Guildford Borough Councils response to ExA's Second Written Questions (Ref: ExQ2)
GBC ref: 19/CON/00026/ExA.Q2

Topic	Guildford Borough Council Response	
3	Air quality and human health		
2.3.6	Applicant and Local Authorities	Have the air quality implications of the Proposed Development for Ripley been robustly assessed within the ES, having particular regard to the number and suitability of receptor properties that have been used [paragraphs 5.3 and 5.4 of REP1/041] and the extent to which the Applicant's modelling has been verified and modified against the monitoring data that is available for Ripley?	The Council has no objection to the number or the suitability of the receptors used in the assessment and that it uses the most up to date data available.
4	Biodiversity and Habitats Regulations Assessment

21. The issue of tree root damage to historic redwood trees along the RHS Garden boundary of the A3 remains in contention. The trees in question are shown on the attached plan.

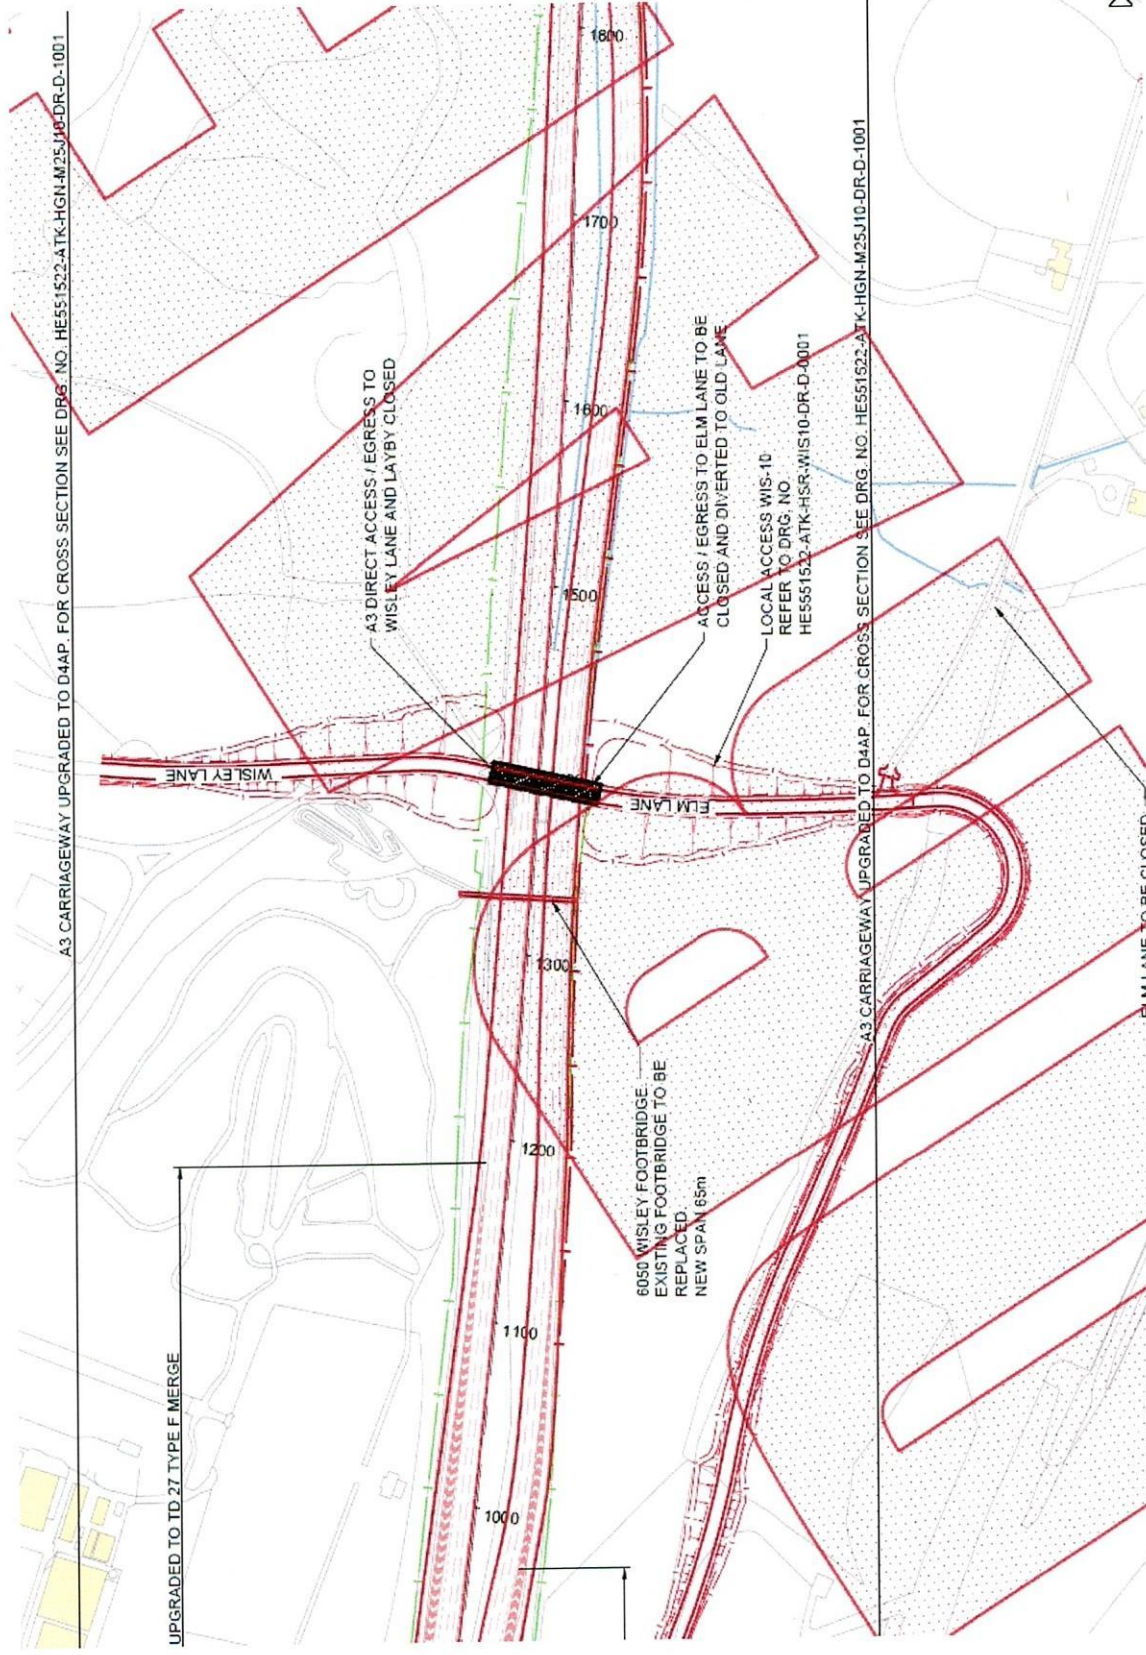
2.8.1	Applicant and LAs	In RHS Wisley's RR [RR-024] and in [REP4-049] reference is made to the possible loss of redwood trees close to the boundary due to tree root impact and this issue not yet being resolved. Please comment on the current situation in regard to your assessment of this as in [REP2-014, page 85] you refer to tree root surveys "still being analysed".	The Council has not undertaken a detailed assessment of the impact of the scheme on tree roots in the vicinity of the proposal. The development will require the removal of a number of trees but post development impact should also be considered in the assessment of the scheme.
